Consultation Response from KC, Highways Development Management
2023/93602 Jamia Masjid Gulzar E Madina, 3 High Street, Westtown, Dewsbury, WF13 2RE
Raising of roof height and erection of first floor extension with hip roof and 3 storey extensions to rear and side elevations
Date Responded: 26-9-2024. Responding Officer: Mark Berry. Responding Ref: 14-9NE-14.

This application seeks approval to the raising of roof height and erection of first floor extension with hip roof and 3 storey extensions to rear and side elevations at Jamia Masjid Gulzar E Madina, 3 High Street, Westtown, Dewsbury.

Drawing title
EXISTING AND PROPOSED
ACCESS PLAN

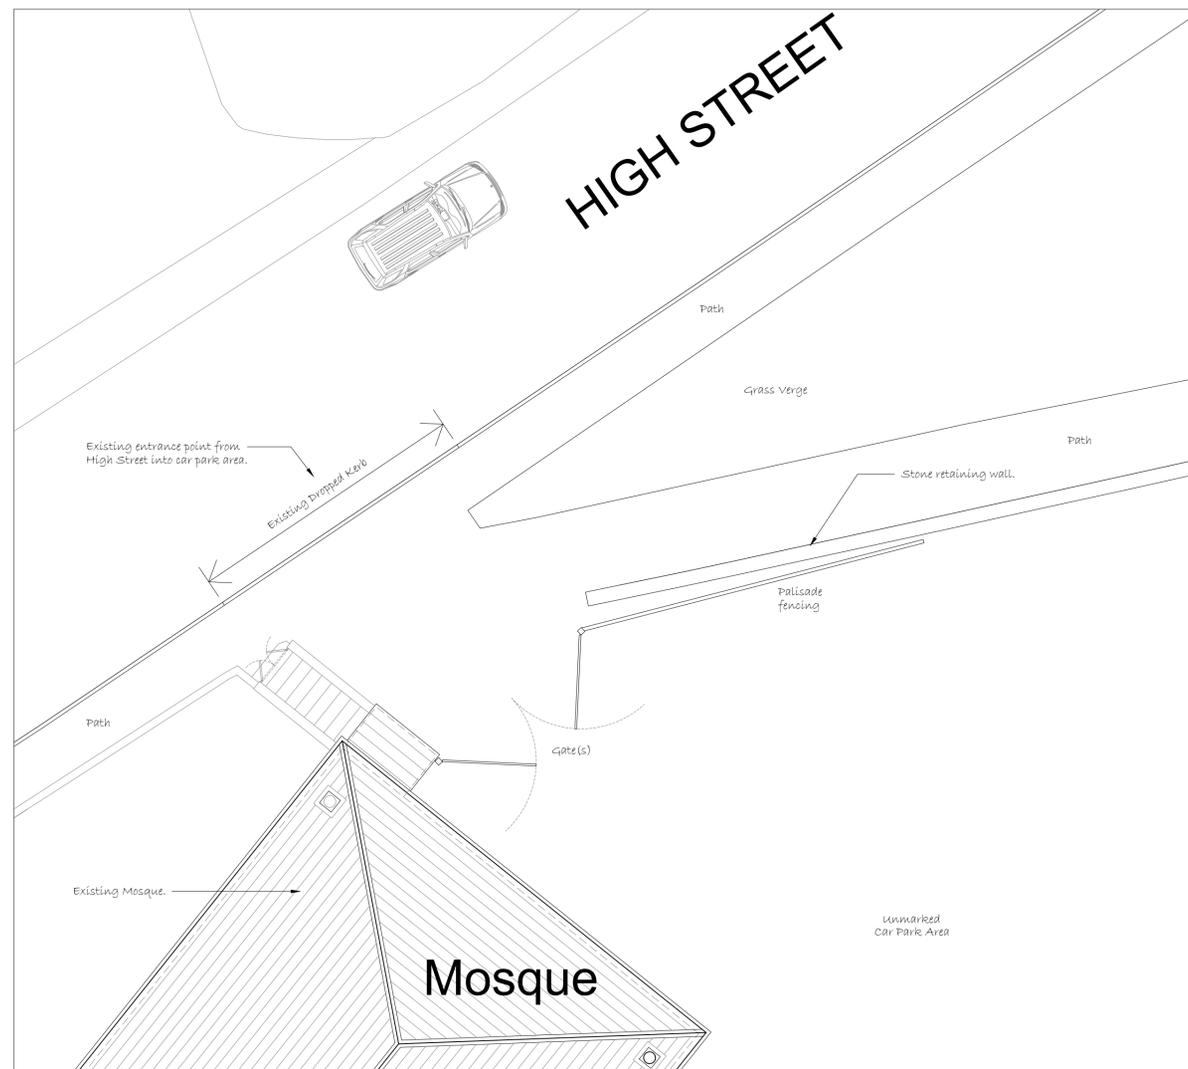
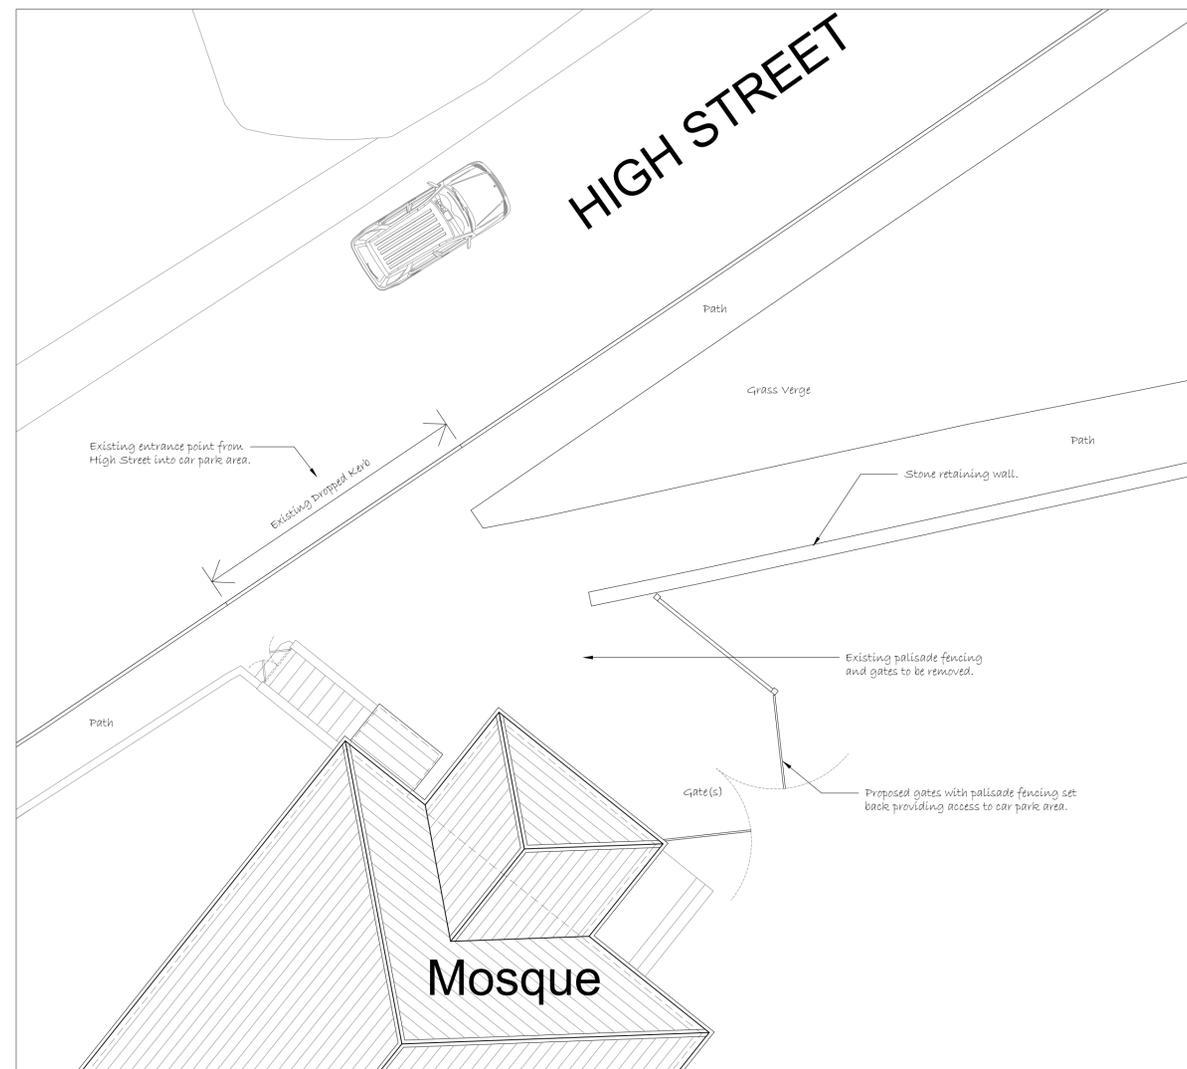
The applicants have also provided plan number PL05 Existing and Proposed Access Plan. This shows the access and stone retaining wall to be retained as existing with just the palisade fencing to the rear adjusted to provide an improved access.

The proposals shown on plan number PL05 Existing and Proposed Access Plan are acceptable.
